STATE OF NORTH CAROLINA  
DEPARTMENT OF TRANSPORTATION

November 24, 2020

**Subject: Request for Modification to Section 404 Individual Permit and Section 401 Water Quality Certification** for the I-40/I-77 interchange improvements including I-40 from west of SR 2003 (Radio Road) to SR 2158 (Old Mocksville Road) and I-77 from south of SR 2321 (East Broad Street) to south of SR 2171 (Jane Sowers Road) in Iredell County. Division 12, TIP No. I-3819B. Debit \$570.00 from WBS 34192.3.2.

**References:** 1) Section 404 Individual Permit, Action ID No. SAW-2018-01504, issued January 21, 2020; 2) Section 401 Water Quality Certification No. WQC004203, NCDWR Project No. 20191006, issued November 19, 2019 and revised January 30, 2020.

PERMIT DRAWING
SHEET 30 OF 67
Rev. 11/02/2020

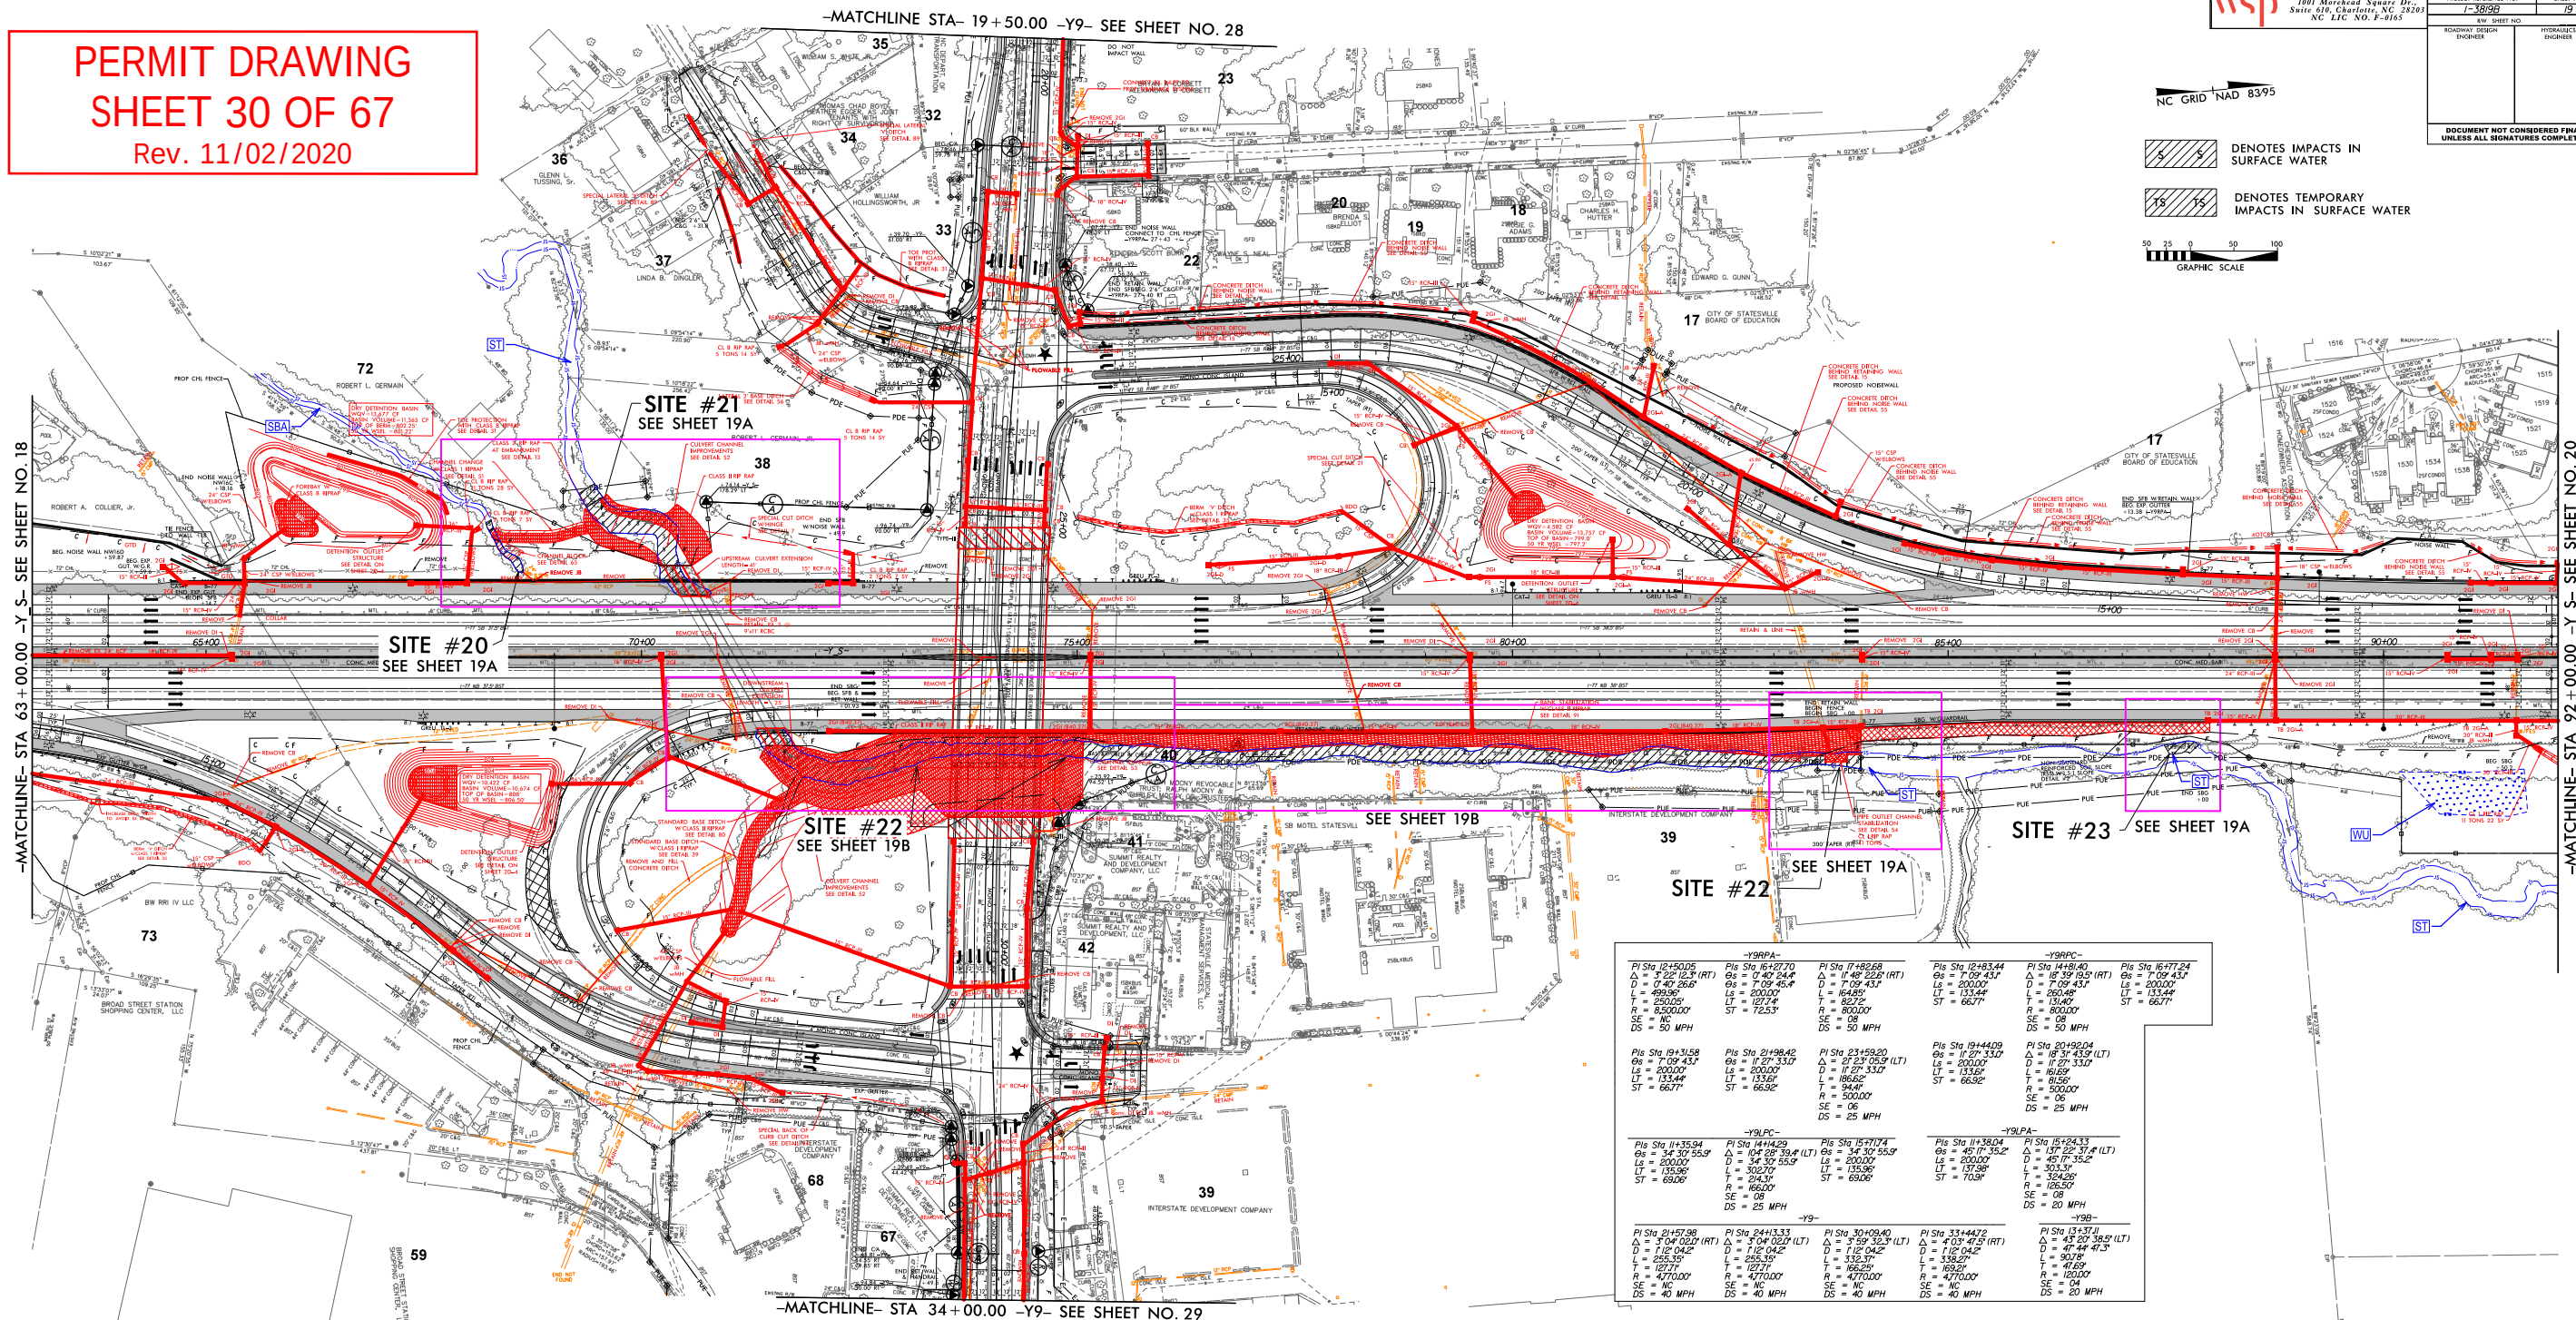
Site 21 (Permit Drawing Sheet 30) – There will be no changes to the design or proposed activities at this site from the approved permit; however, the jurisdictional stream boundaries of stream ST have been revised to more accurately follow the surveyed topographic contours. This revision will not result in any changes to the linear feet of permanent and temporary stream impacts. The total acreage of permanent stream impacts increased from 0.08 acre to 0.10 acre as a result of the revised jurisdictional stream boundary; temporary stream impacts will remain <0.01 acre.

Site 22 (Permit Drawing Sheet 30) – The jurisdictional stream boundaries of stream ST have been revised from those shown in the approved permit to more accurately follow the surveyed topographic contours. This revision will not result in any changes to the linear feet of permanent stream impacts for Site 22. Other revisions to impacts at Site 22 are as follows: in the approved permit, the permanent stream bed stabilization impacts were incorrectly calculated to extend 12 linear feet outside of the riprap in stream ST for the pipe outlet channel stabilization located at Station Number 83+85+00-Y. Also, in this location the permanent stream bank stabilization impacts should have been extended to the end of the riprap shown on the stream bank immediately adjacent to the channel, therefore the permit drawings have been revised to show an additional 16 linear feet of permanent stream bank stabilization impacts. Permanent stream bed impacts will decrease from 467 linear feet to 455 linear feet and bank stabilization impacts will increase from 873 linear feet to 901 linear feet. The previously approved 10 linear feet of temporary stream impacts were no longer needed and have been removed.

Site 23 (Permit Drawing Sheet 30) – There will be no changes to the design or proposed activities at this site from the approved permit; however, the jurisdictional stream boundaries of stream ST have been revised to more accurately follow the surveyed topographic contours. This revision will not result in any changes to the linear feet or acreage of temporary stream impacts at this location.
